From: Thomas Callaway
Sent: 28 April 2015 13:52
To: Planning.Responses
Subject: RE: Planning Consultation on: Y/29/15/HH

APPLICATION NO: Y/29/15/HH

Site Address: 1 Turpins Mount Main Road Yapton BN18 0EU

Description of Works: Garage conversion & link within the Main Road/Church Road Conservation Area.

15/4243/3

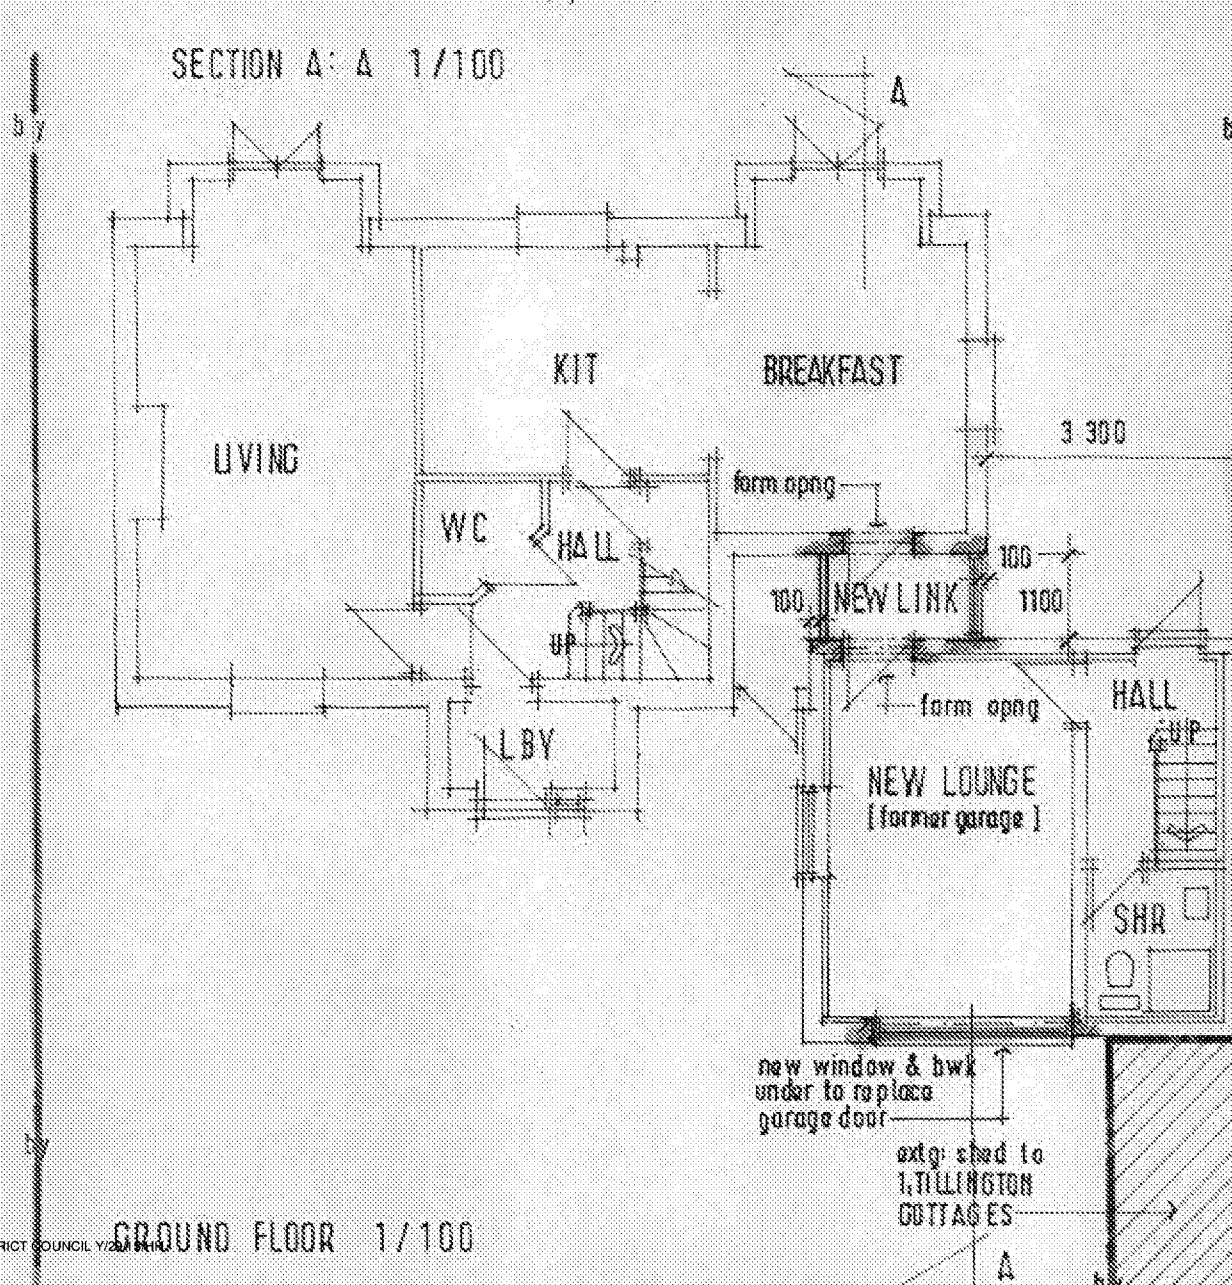
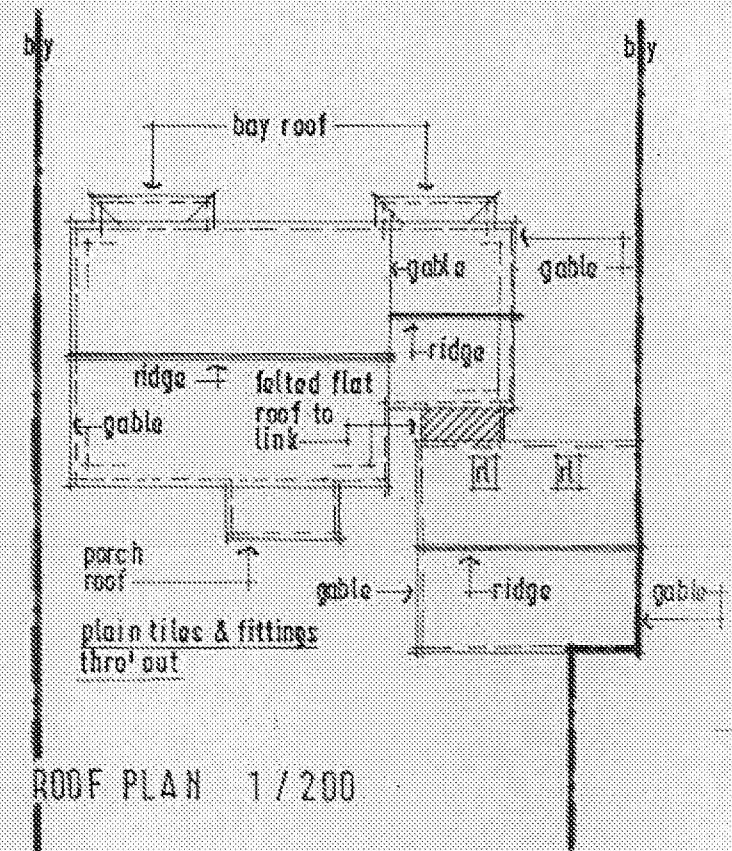
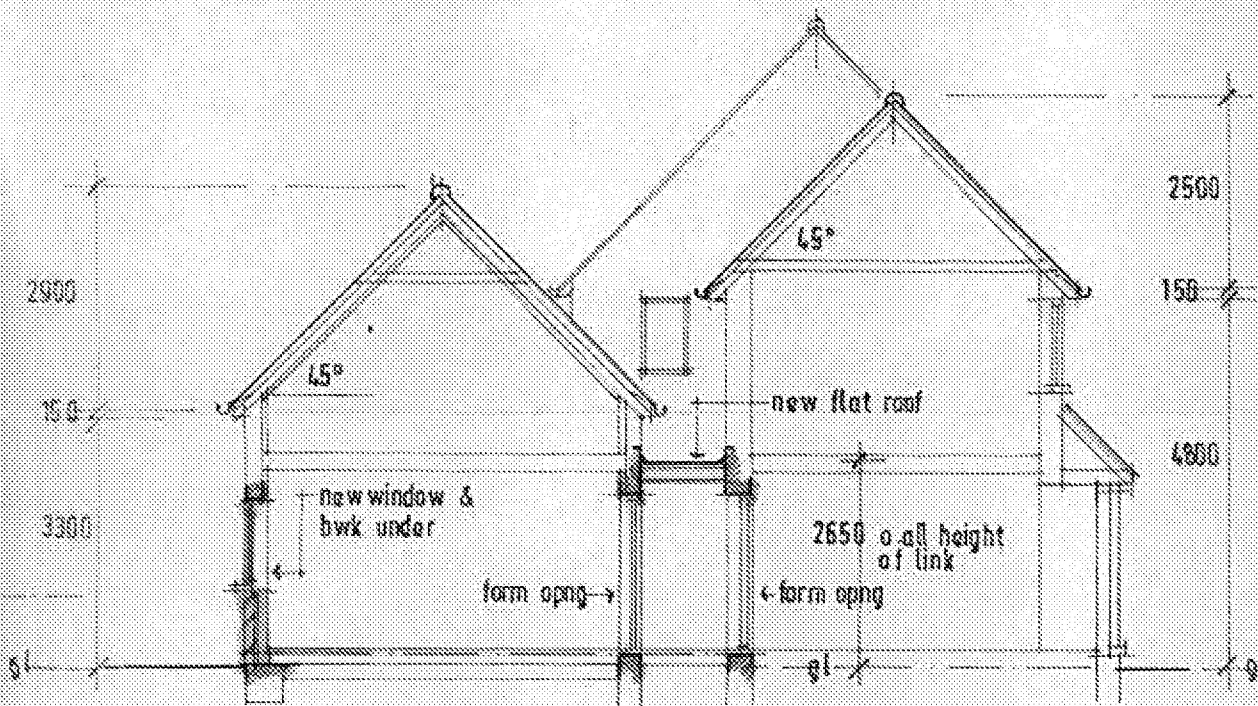
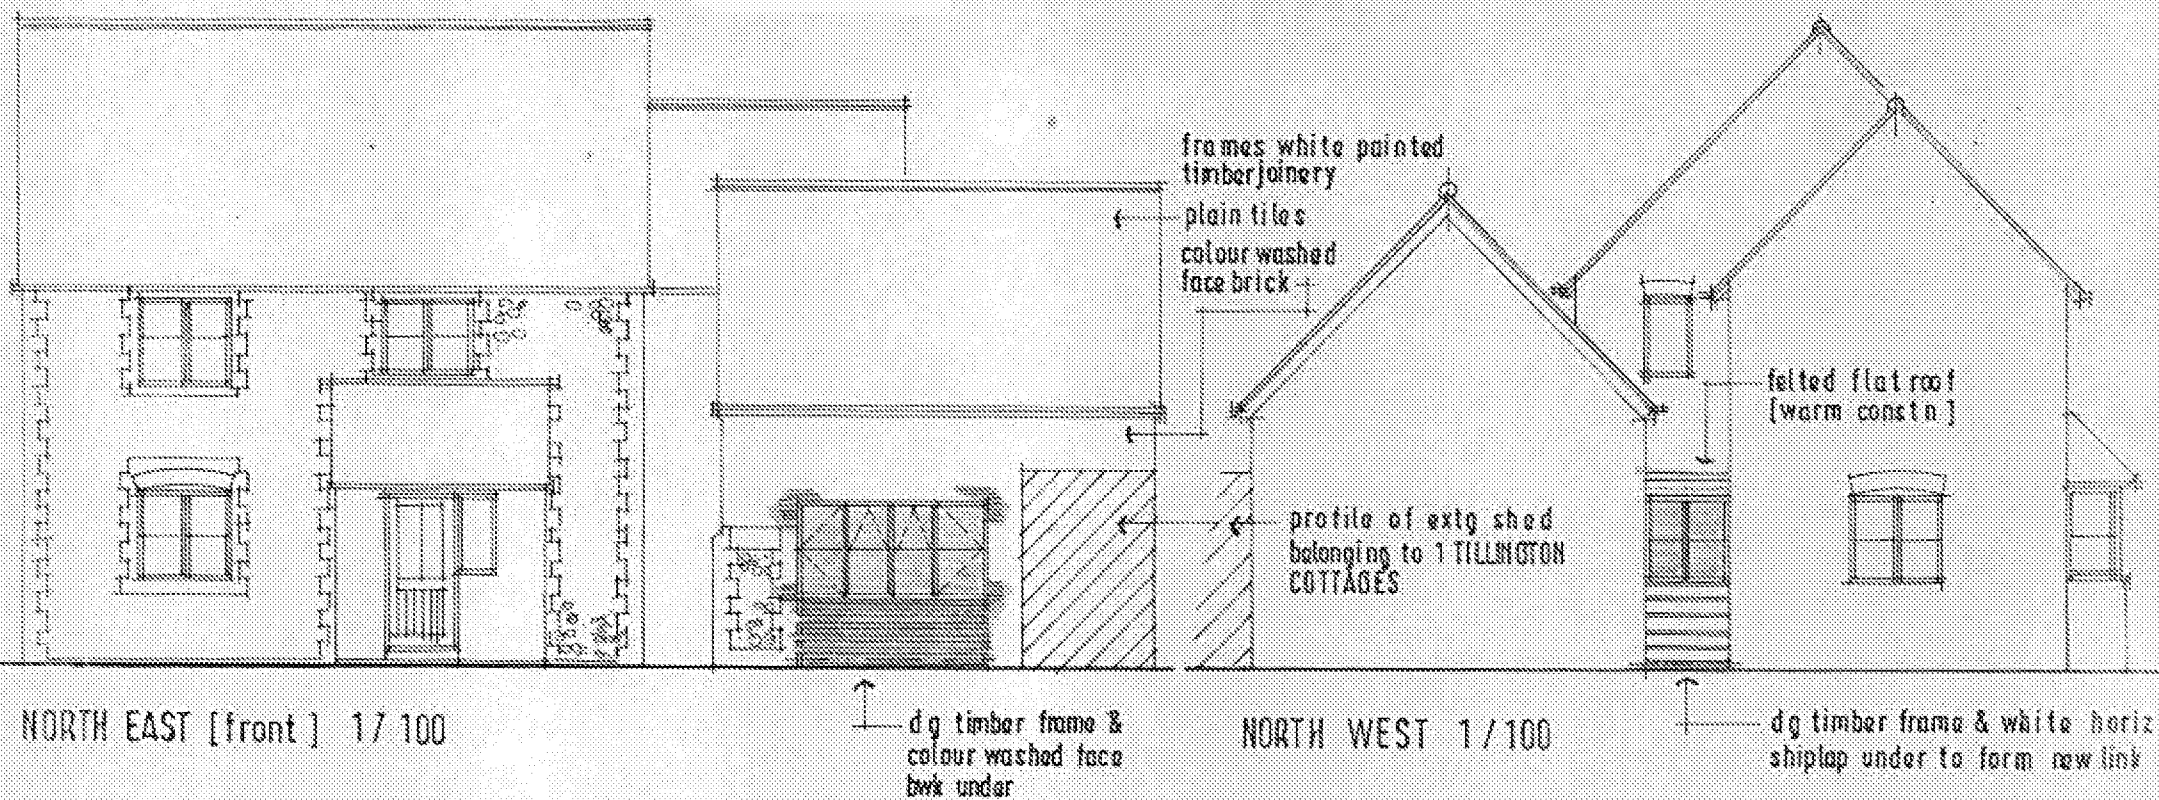
Surface water drainage should be provided for new roof area. Infiltration to be investigated.

Infiltration rates for soakage structures are to be based on percolation tests undertaken in the winter period and at the location and depth of the proposed structures. The percolation tests must be carried out in accordance with BRE 365, CIRIA R156 or a similar approved method and cater for the 1 in 10 year storm between the invert of the entry pipe to the soakaway, and the base of the structure. It must also have provision to ensure that there is capacity in the system to contain below ground level the 1 in 100 year event plus 30% on stored volumes, as an allowance for climate change. Adequate freeboard must be provided between the base of the soakaway structure and the highest recorded annual groundwater level identified in that location.

Any SuDS or soakaway design must include adequate groundwater monitoring data to determine the highest winter groundwater table in support of the design. The applicant is advised to discuss the extent of groundwater monitoring with the Council's Engineers. Supplementary guidance notes are also enclosed for information.

Please apply standard conditions ENGD2A.
